From: Mandy O'Brien [REDACTED]
Sent: 22 April 2022 19:43
To: Obafemi Okusipe <Obafemi.Okusipe@arun.gov.uk>
Subject: Planning Application LU/79/22/PL

Re: Planning Application LU/79/22/PL

PROPOSED ROOF TERRACE COMPUTER GENERATED VISUALS FOR REFERENCE

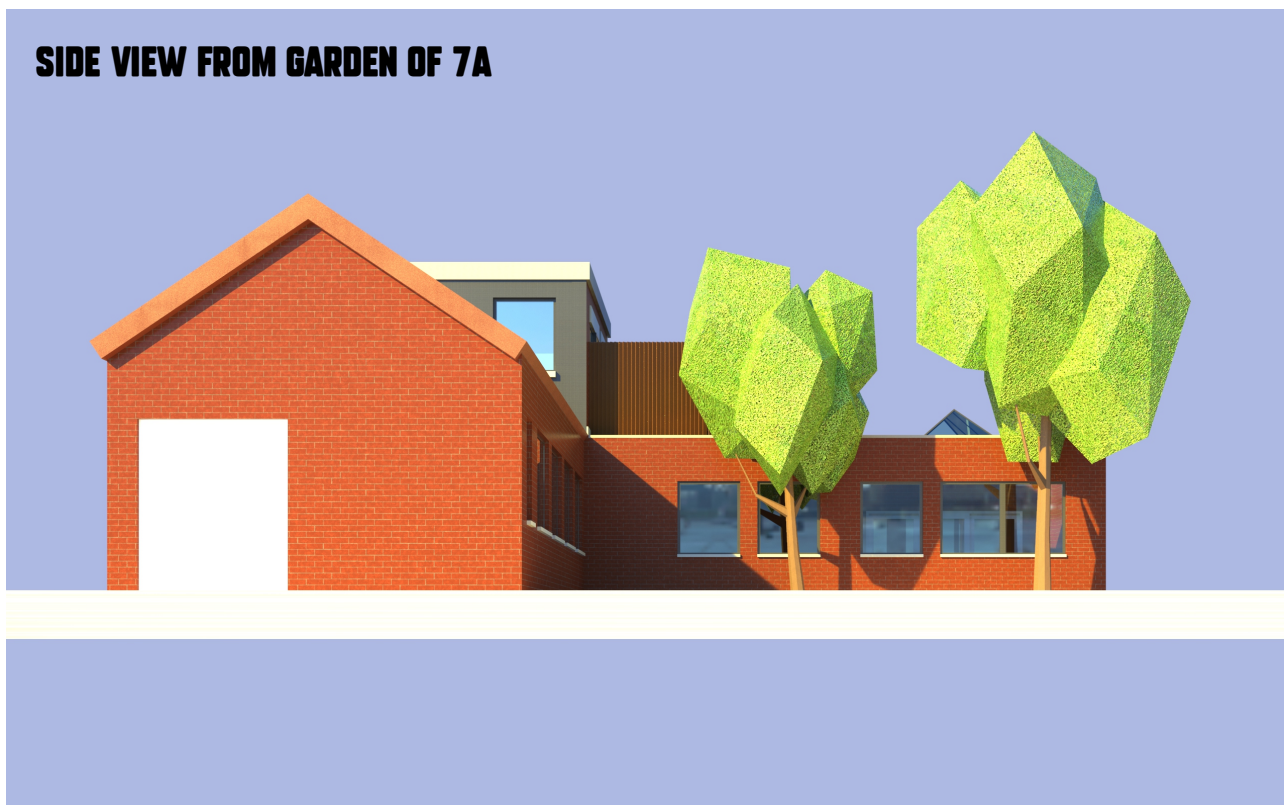
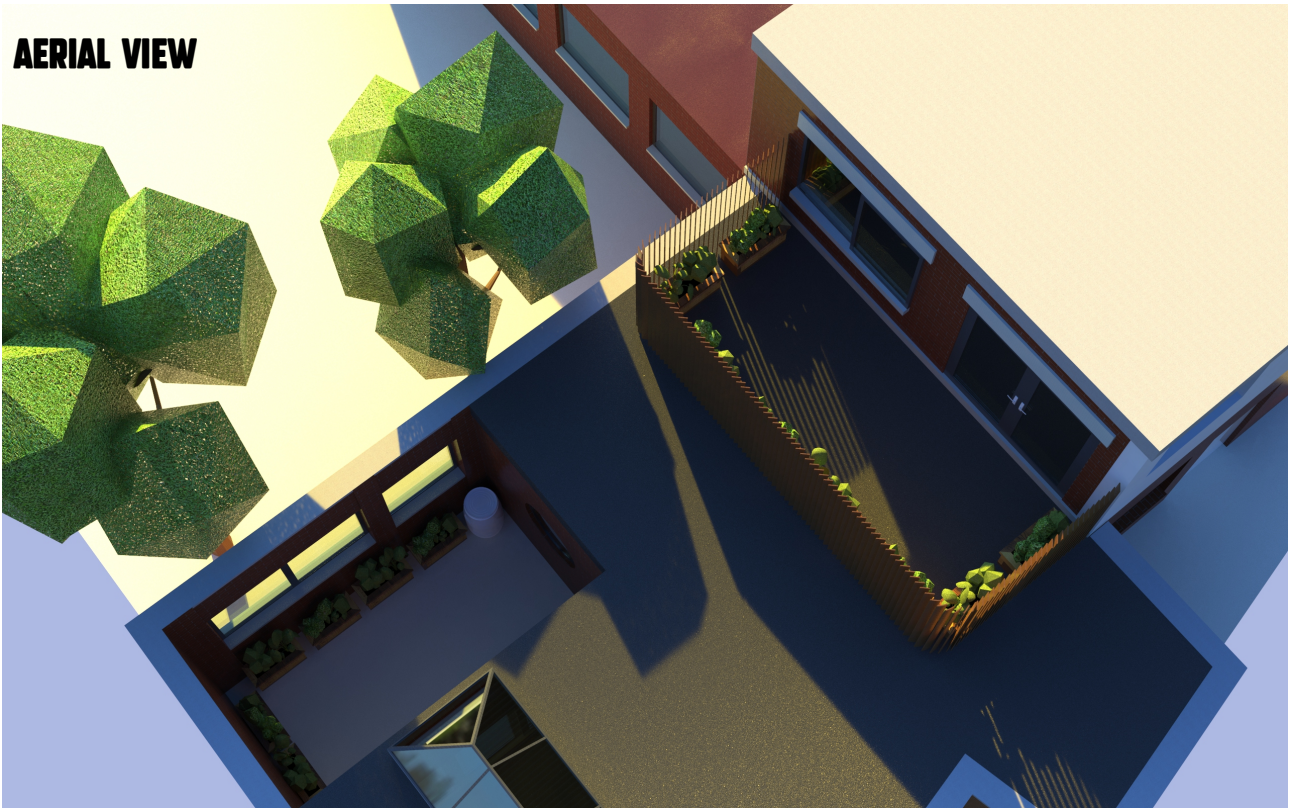
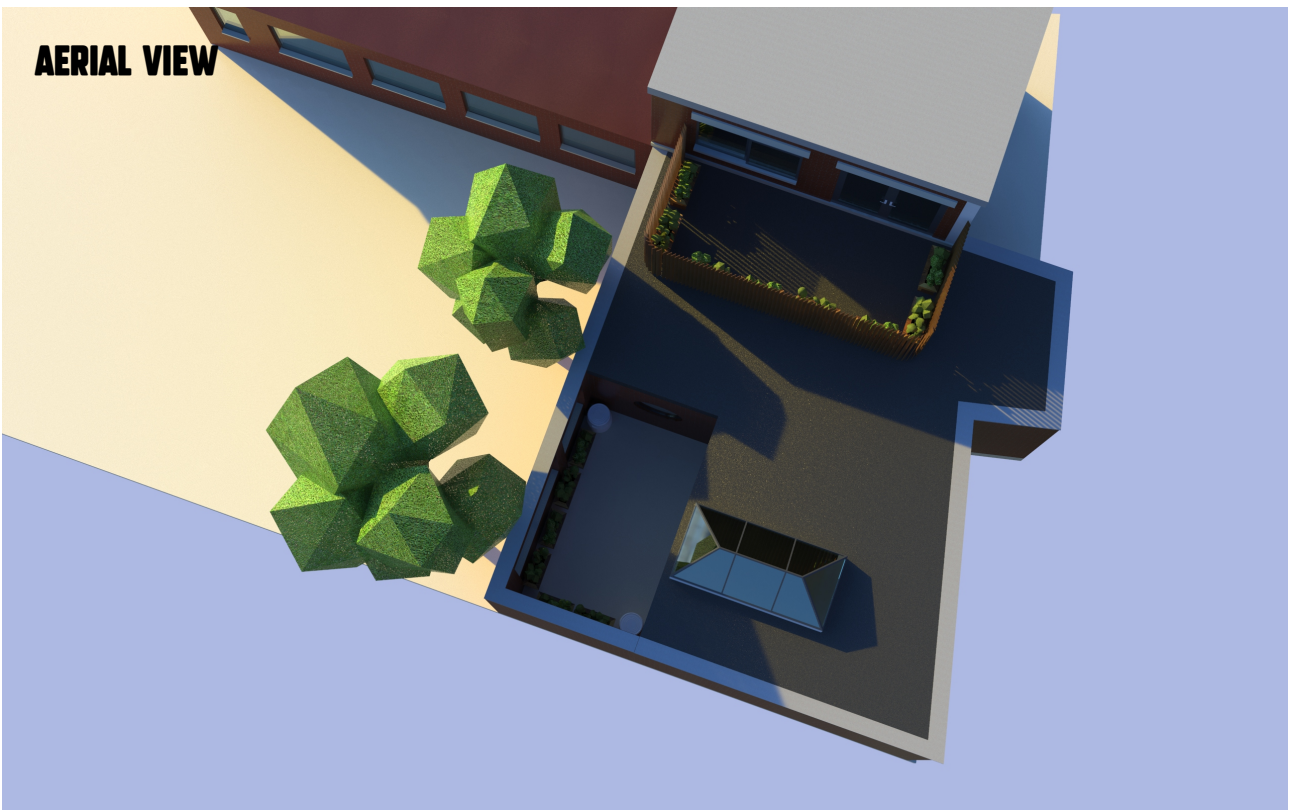
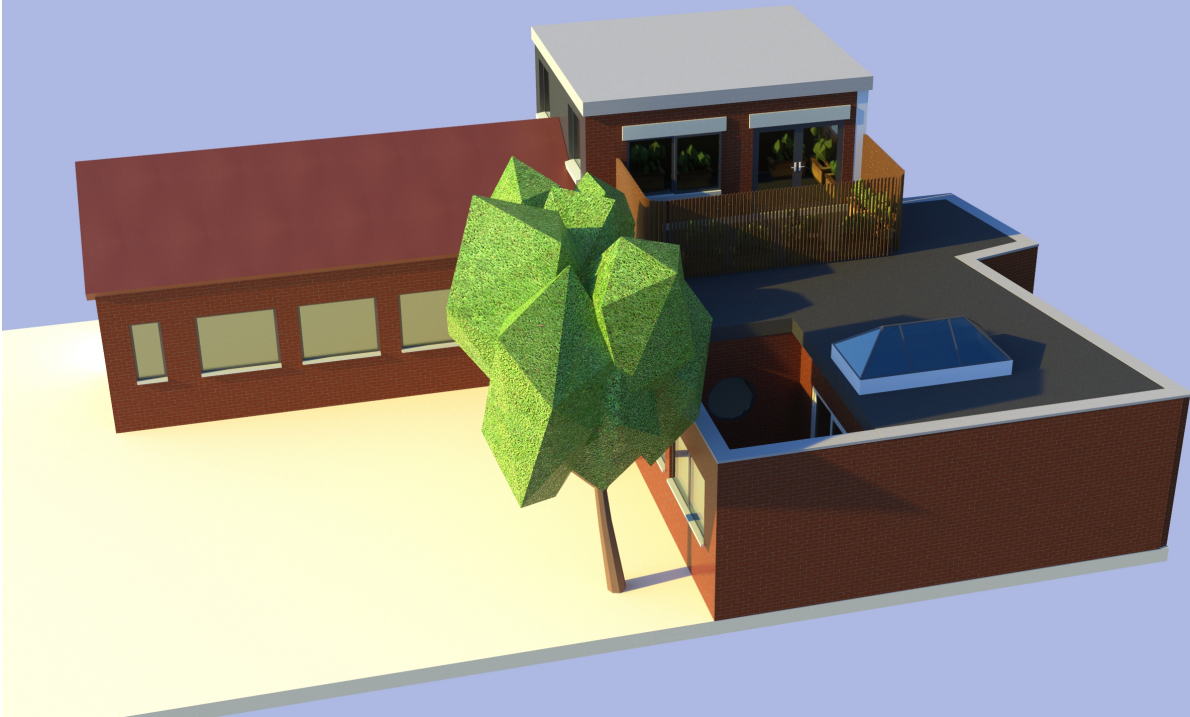
- Point 5.14: That the screening of the rook terrace is sufficient to limit noise and light pollution in the Courtyard garden of the Georgian House and is of sufficient durability to prevent screening damage in the storms or further debris falling in the Georgian House garden.
- Point 5.21/3: Please could clarification be sought as to how “the curved louvred timber screening” will be secured to the roof terrace and be maintained in good repair. This is asked, as under the previous planning application LU/340/21/PL, pots had fallen from the flat roof into the courtyard garden of the Georgian House which was a risk to property and person.
- As per comments made to Planning Application -LU/340/21/PL - Old Printworks, please could clarification be sought within the planning agreement as to how the light pollution from the windows into the Georgian
